Re: MP09\_0154 – Mirvac Projects Pty Ltd, 7 Railway Street Chatswood

I am an owner in the Regency complex at Chatswood which is in very close proximity to 7 Railway Avenue. Mirvac Pty Ltd (Mircac) has made application for a mixed use commercial/residential building. It is substantially different from what is presently proposed. I strenuously am against granting the application for the following reasons.

SHADOW DIAGRAM - MARCH 20TH / SEPTEMBER - 9am

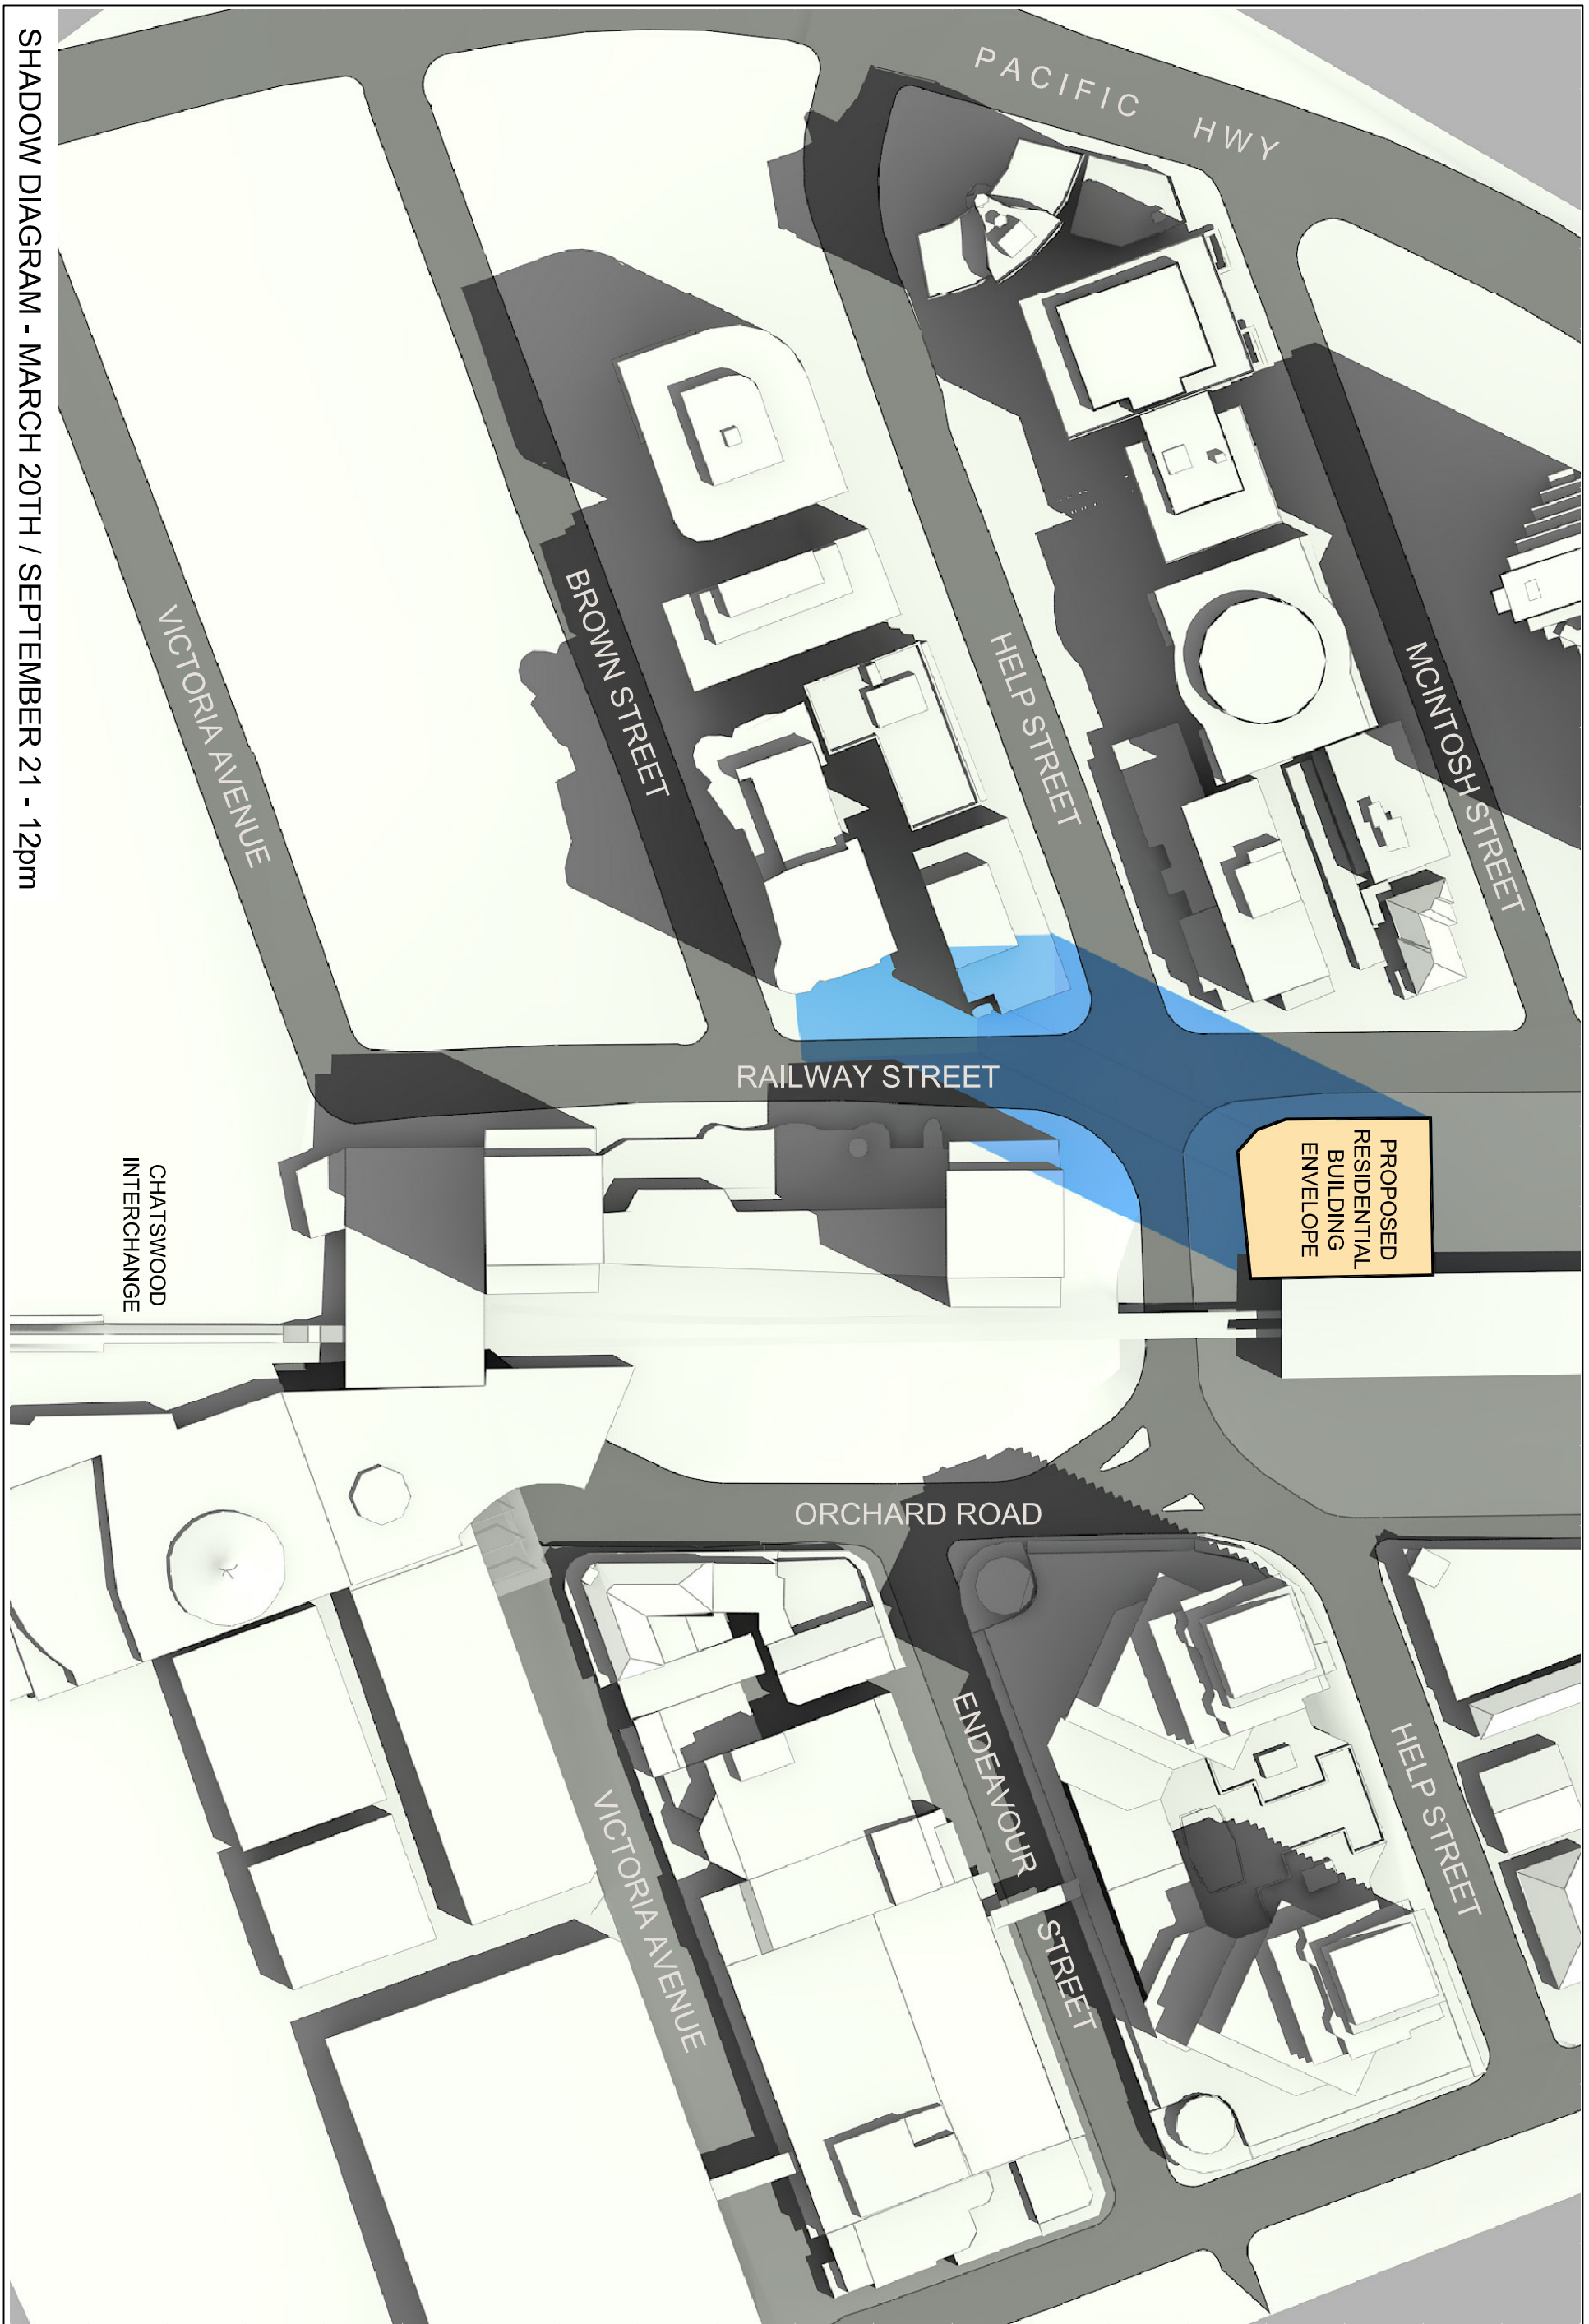
7. In the submission there is evidence that our building will be affected by shadowing in the afternoons from a 40 plus storey tower. At the Regency we have spent the last two years planning and ensuring funding to install 2 x 10 KW solar systems on our 2 roof top areas. If Mirvac is allowed to construct this 40 plus storey tower our solar system would be adversely affected. The shadowing will also significantly affect 1/4 of our buildings including the diminished enjoyment of use of their balconies in the afternoon and evening.
